Meeting note

File reference	EN010069 Abergelli Power Project
Status	Final
Author	Ewa Sherman
Date	25 February 2015
Meeting with	Abergelli Power Limited (APL)
Venue	Temple Quay House, Bristol BS1 6PN
Attendees	Planning Inspectorate (PINS) Tom Carpen – Infrastructure Planning Lead Susannah Guest - Infrastructure Planning Lead Jenny Colfer – EIA and Land Rights Advisor Stephanie Newman – Case Manager Ewa Sherman – Case Officer Vicki Hodgson - Legal Applicant Adam Heffill – Abergelli Power Limited Gary McGovern - Pinsent Masons Dermot Scanlon - Peter Brett Associates LLP
Meeting objectives	Project update. The Planning Inspectorate’s comments on further draft application documents.
Circulation	All attendees

Detailed comments on the draft DCO application documents submitted to PINS on 30 January 2015.

Dwg no: J0008302-18-2.3.1

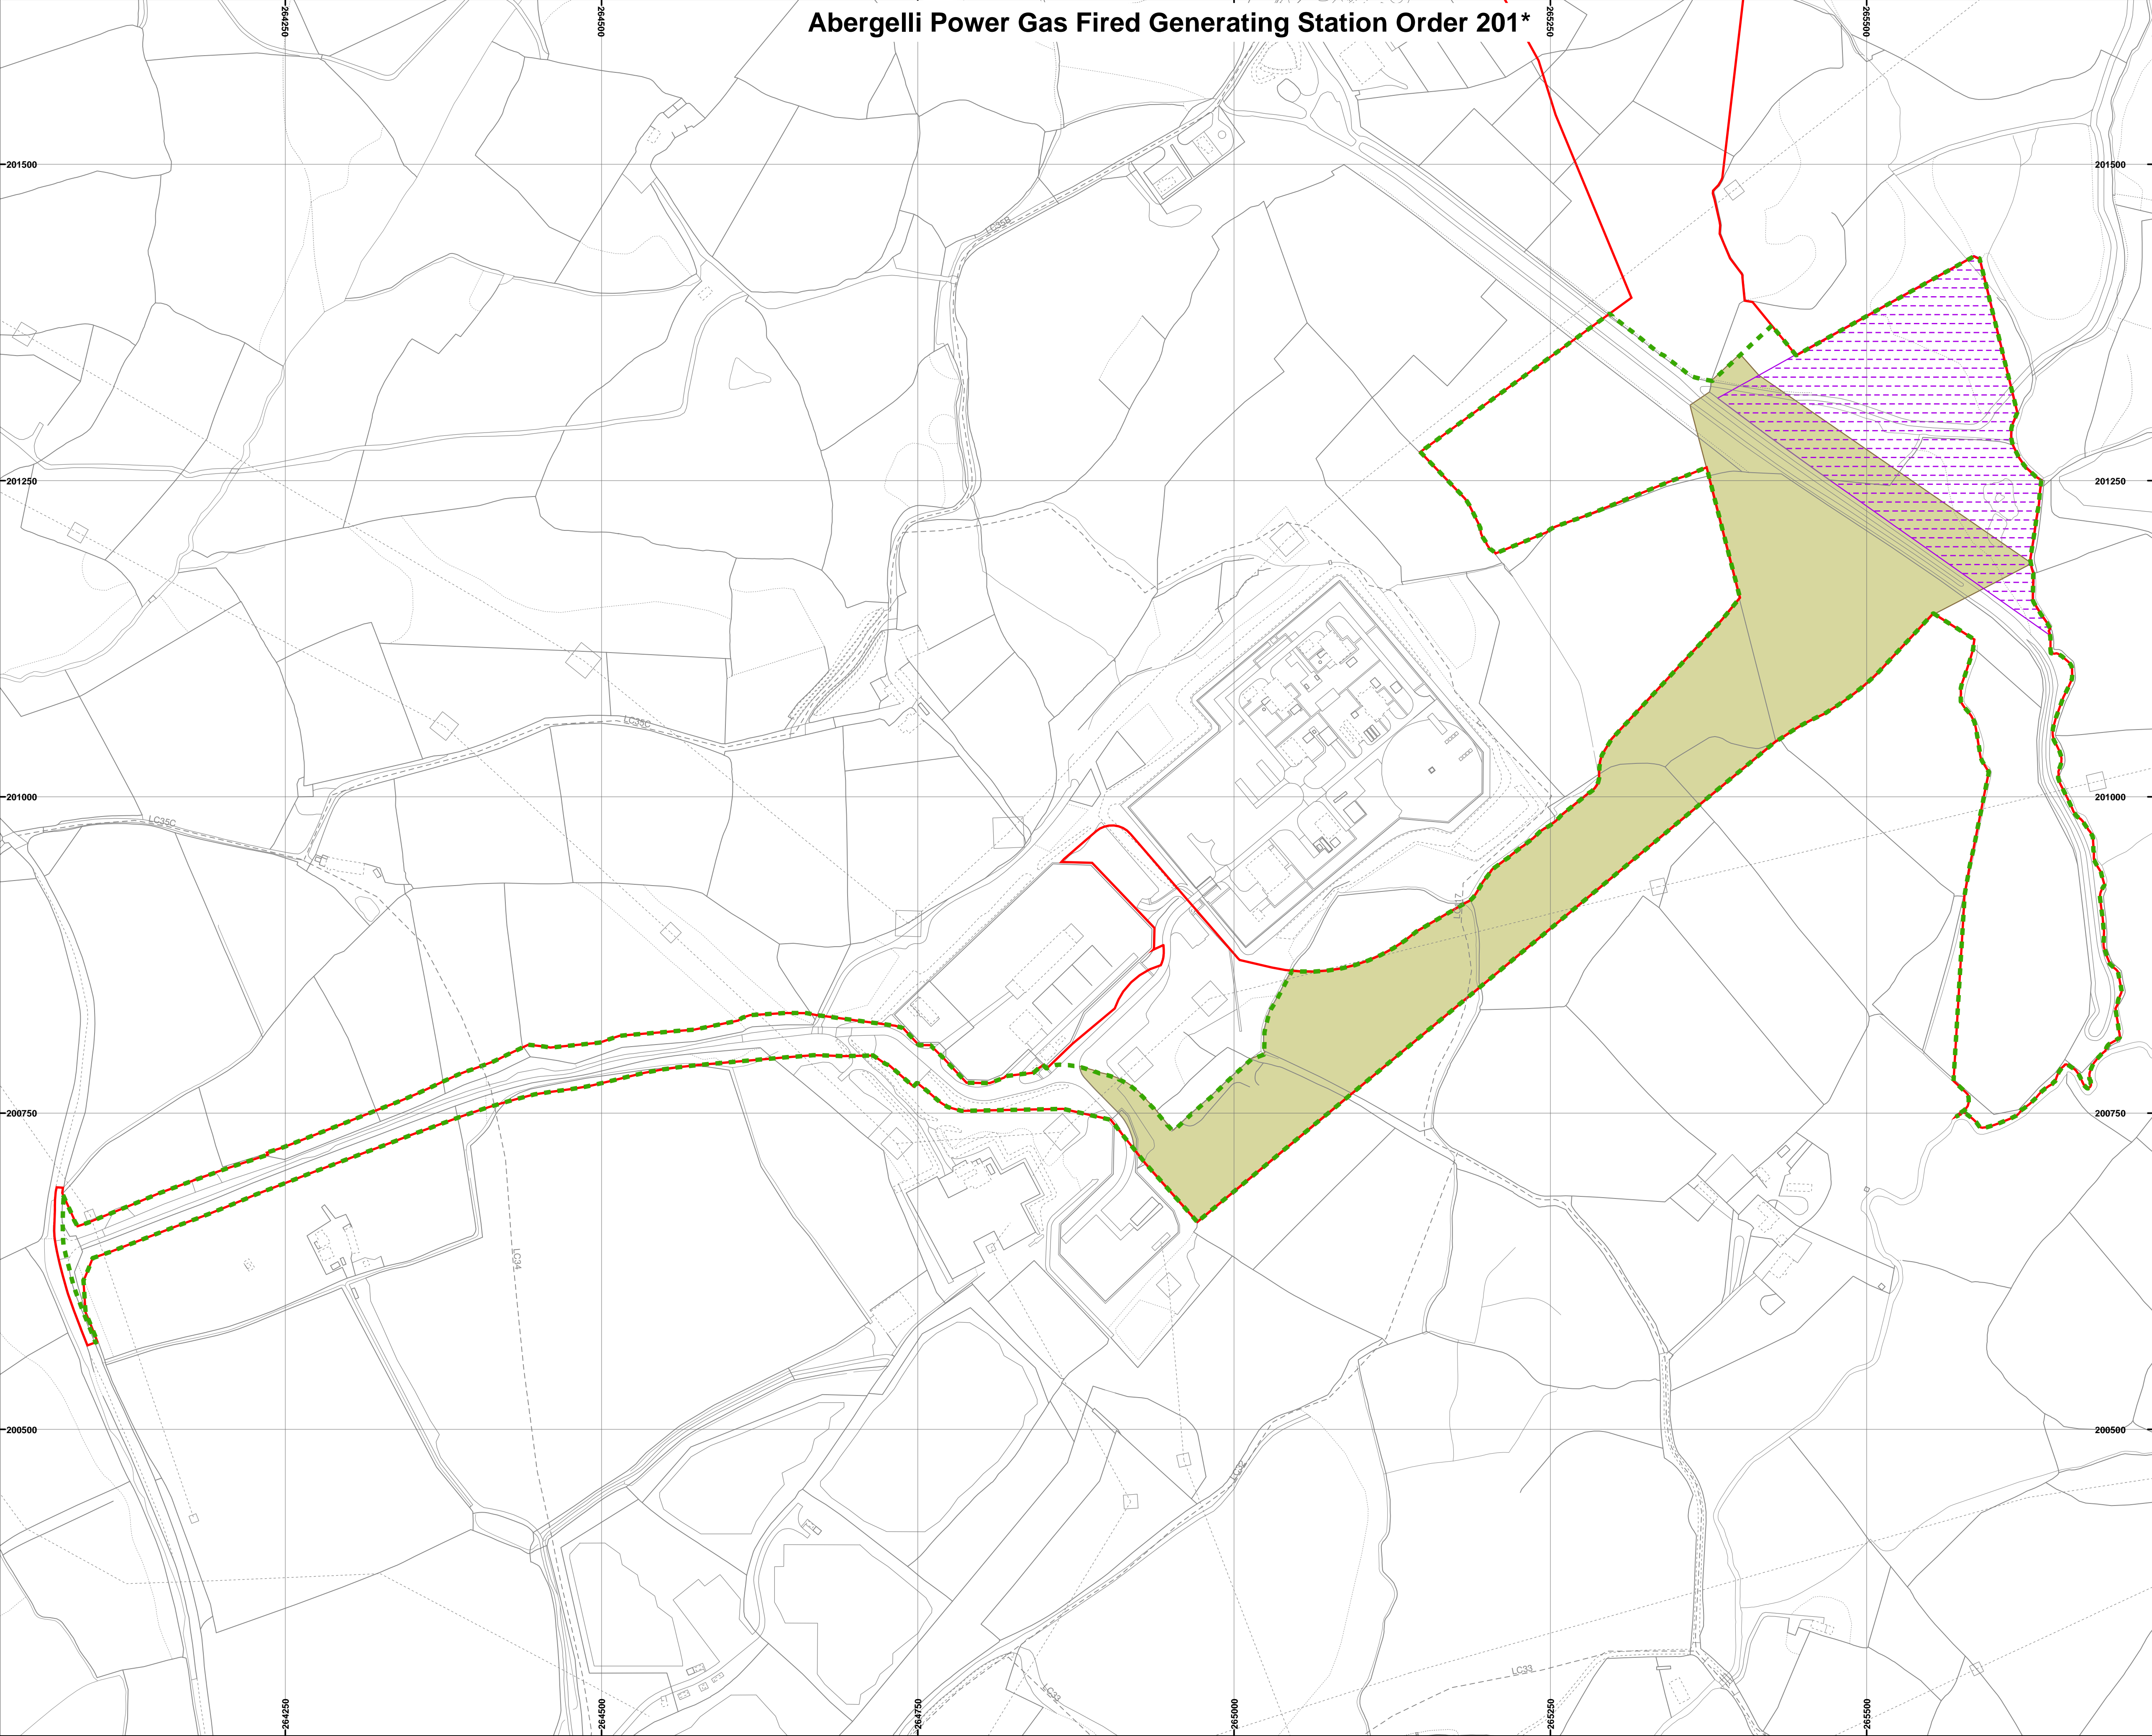
1. Schedule 1 of the draft DCO lists parts of the Authorised Development comprising of Works 1A, 1B, 1C, 1D, 1E, 1F, 2, 3A, 3B, 4, 5A and 5B which have all been included in the Works Plans. However:

- Text describing Numbered Work 5A refers to Work 4B, however Work 4B does not appear on the Works Plans at all.
 - Text describing Numbered Work 2 states that the pipeline will connect the natural gas receiving station in Work 1B to Work 1D. This explanation is not very clear, as the green area on the plan representing Work 2 does not touch Work 1B and therefore does not appear to connect it.
